Our Ref: BN/23/20/DOC

Approval of details reserved by condition imposed under ref BN/23/15/PL relating to Condition No 5 - surface water drainage, 6 - discharge of any flows to watercourses and 7 - future access & Maintenance of any watercourse or culvert

Coniston Lake Lane Barnham PO22 0AD

Arun District Council have decided to **REFUSE details reserved by condition for the following reasons:**

STC DESIGN DEVELOPMENT LTD	
<i>Consulting Structural and Civil Engineers</i>	
Mobile: 07971 404 033	Email: tonyrist@sccdesigndev.com
Title	Scale 1:200 @ A3
AS BUILD DRAWING	4 LAKE LAKE BRANCH
Date	Drawn by
Job no.	Drawing No.
Revision	Revision

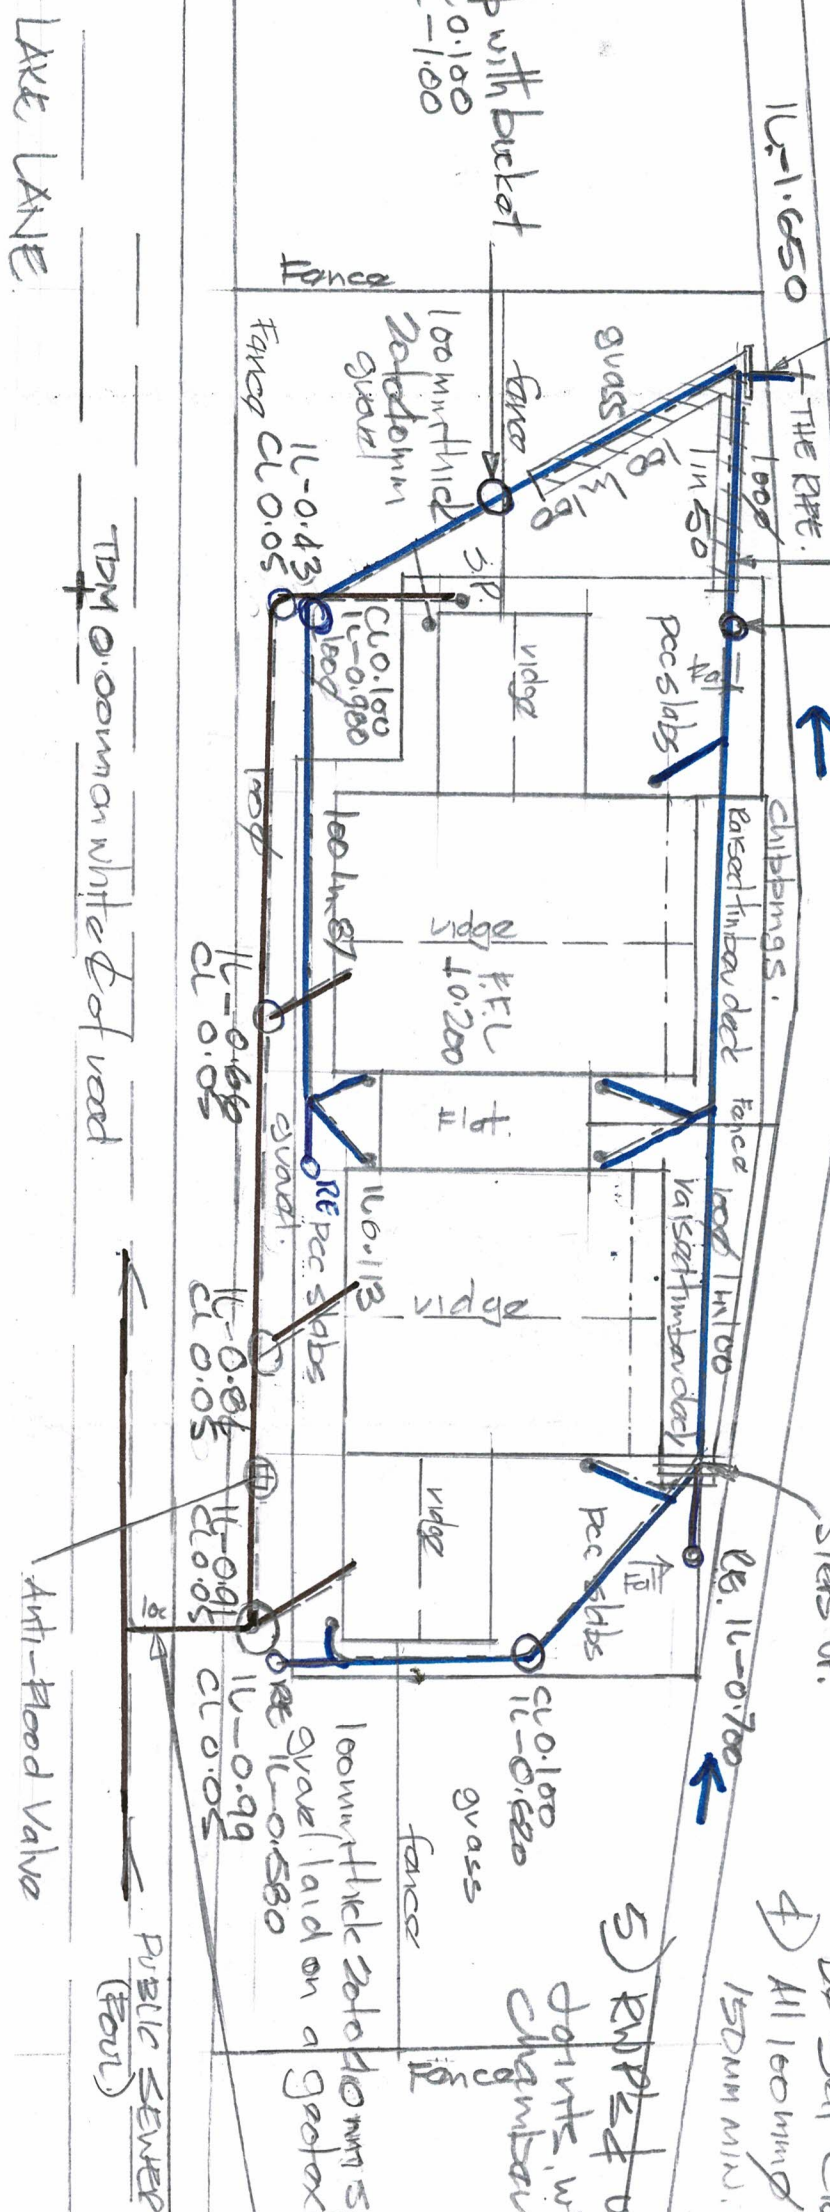
- Numerous invert levels have been changed. The invert level of the silt trap manhole is not clear (- 0.900?), neither is the rodding eye invert level. Please provide clarity on the drawing.
- Revised drawing 535/02 has not been received.
